modular single family
Project Name/Description

September 17, 2003

Subject: 30 Central Avenue Extension
(ID # 2003-0184) (CBL# 088K035)

REVISION: 10-16-03~ADDED EROSION CONTROL AND NOTES.  
**SITE PLAN**  
 FOR A PROPOSED SINGLE FAMILY HOME  
 30 CENTRAL AVENUE EXT. PEAKS ISLAND, MAINE  
 FOR: RICHARD D. GRANT

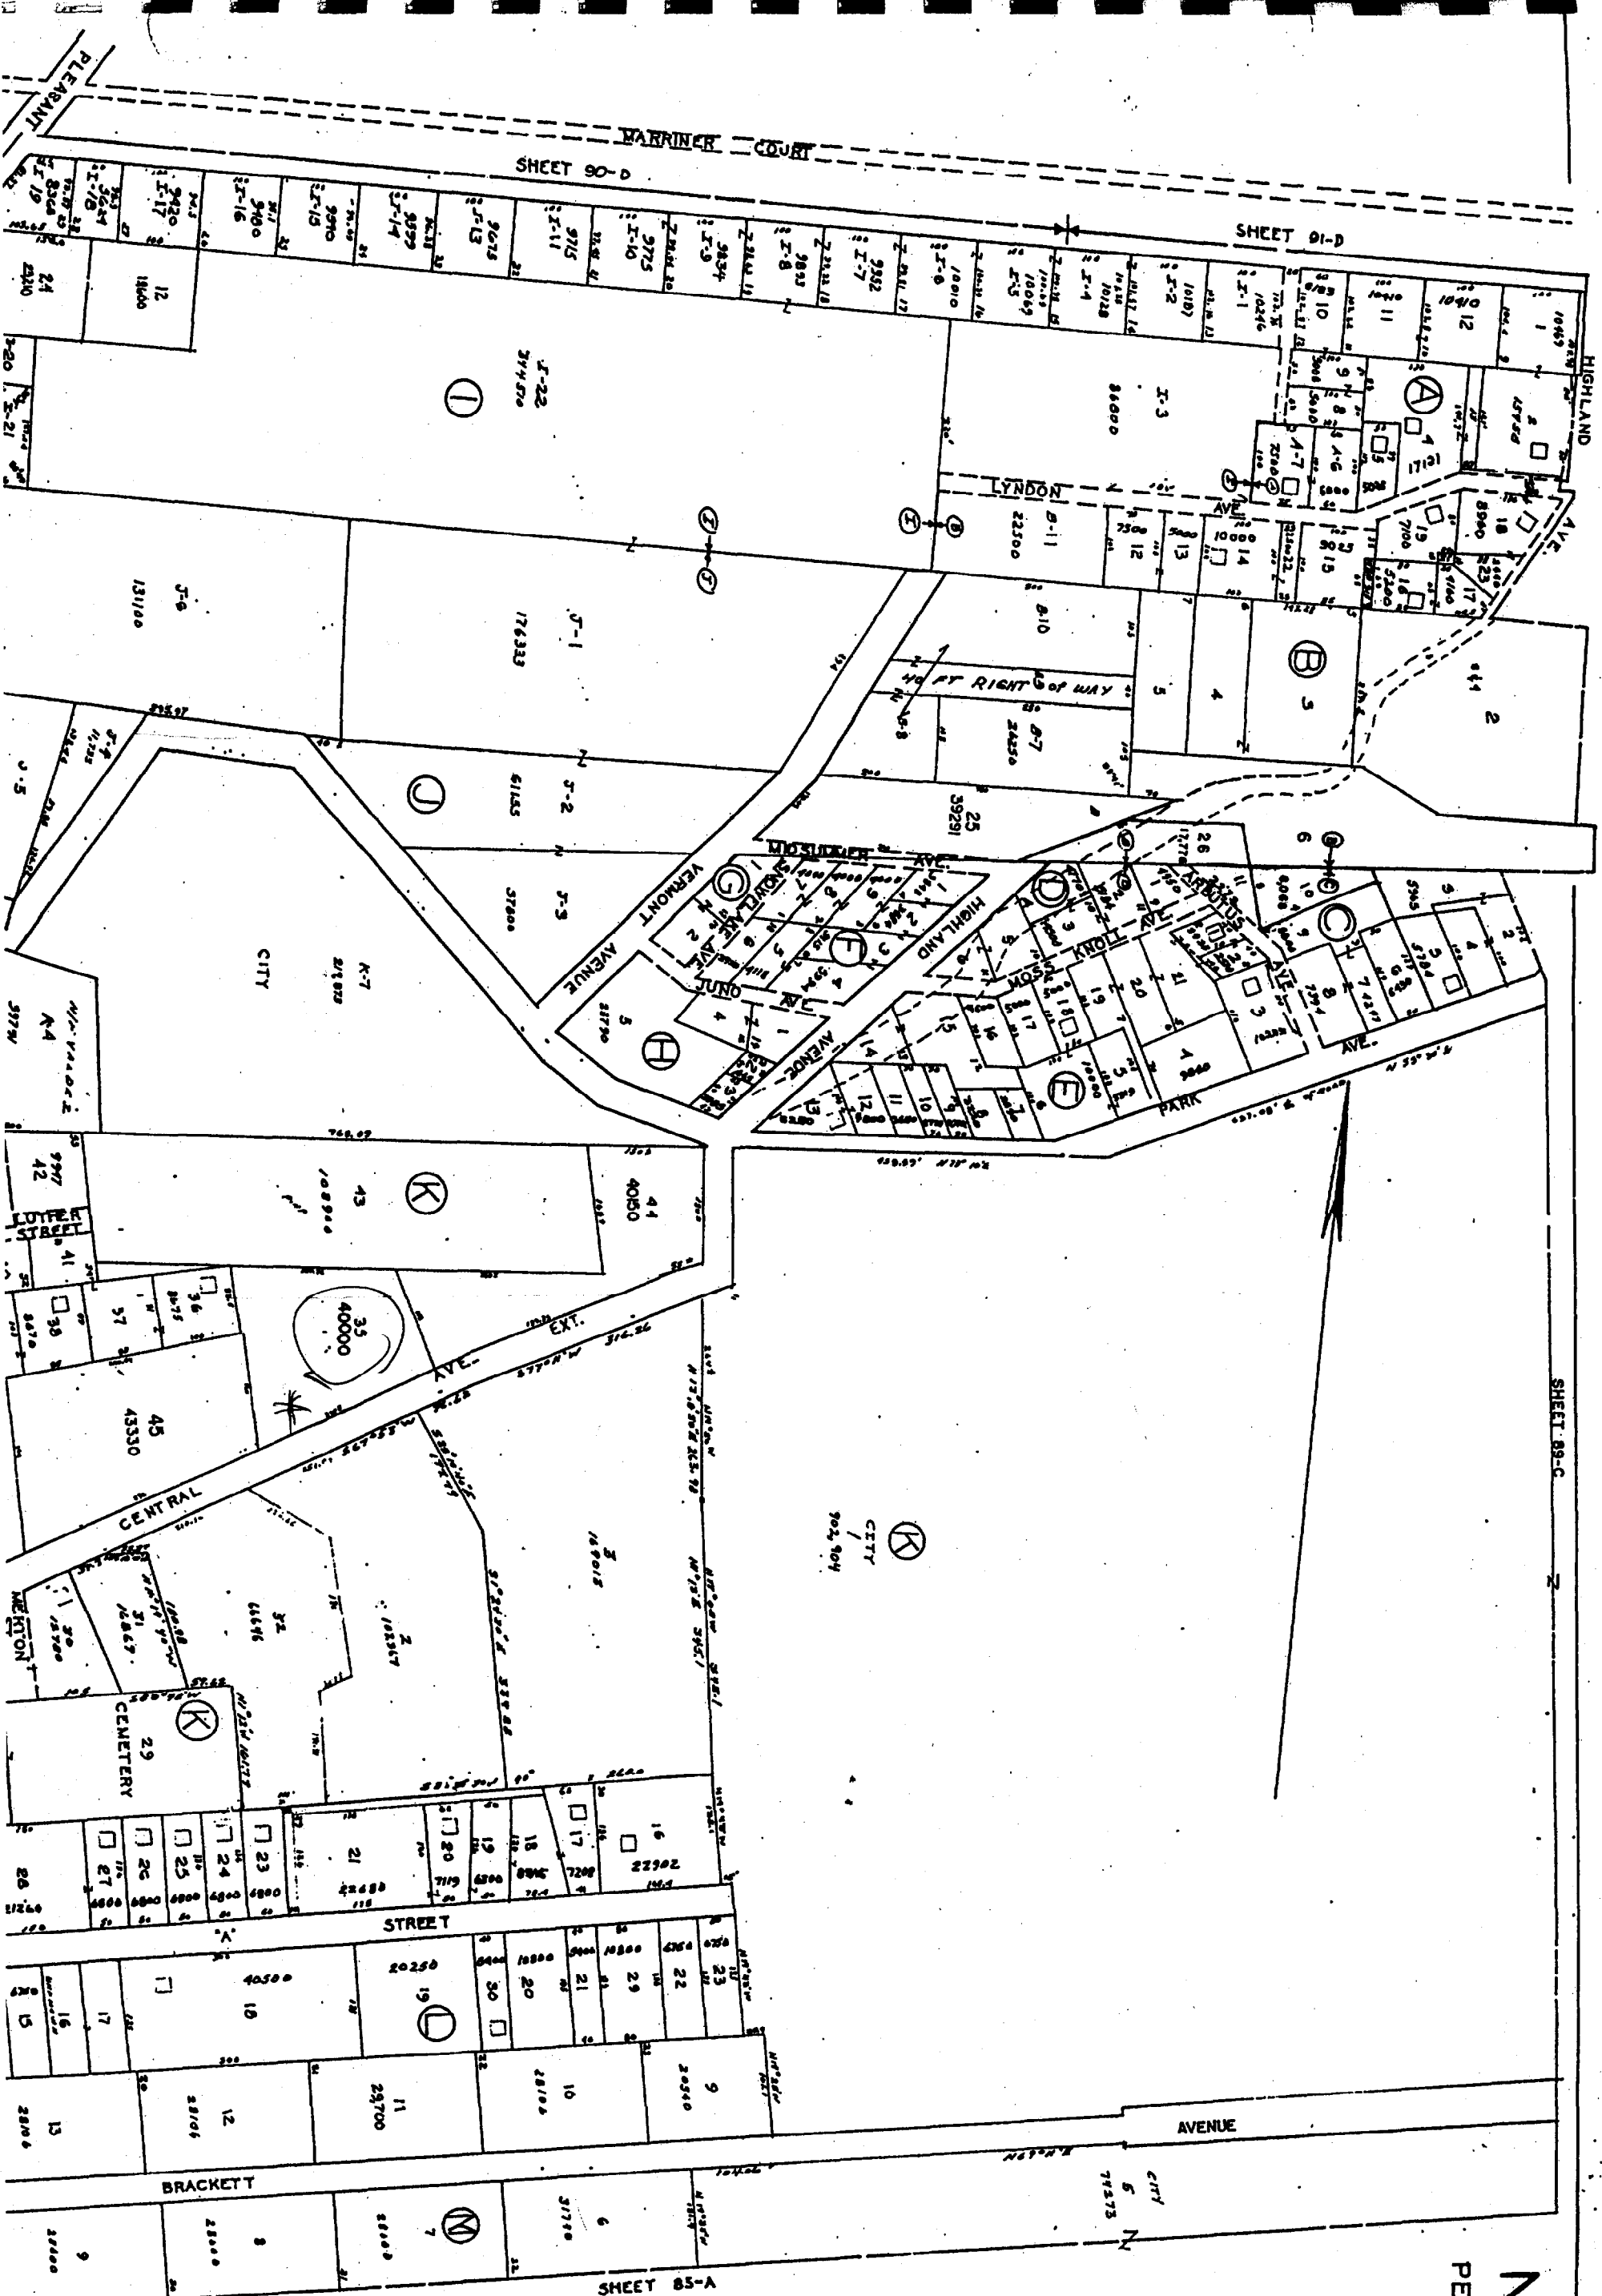
1. Is this lot within the Shoreland zone? If so, please show the 250' setback line and limits of clearing.
2. There appears to be no grading changes to the east side of the proposed structure. Does the building have a daylight basement or will it have approximately 7 feet of wall showing?
3. Please add erosion control measures to the site plan.
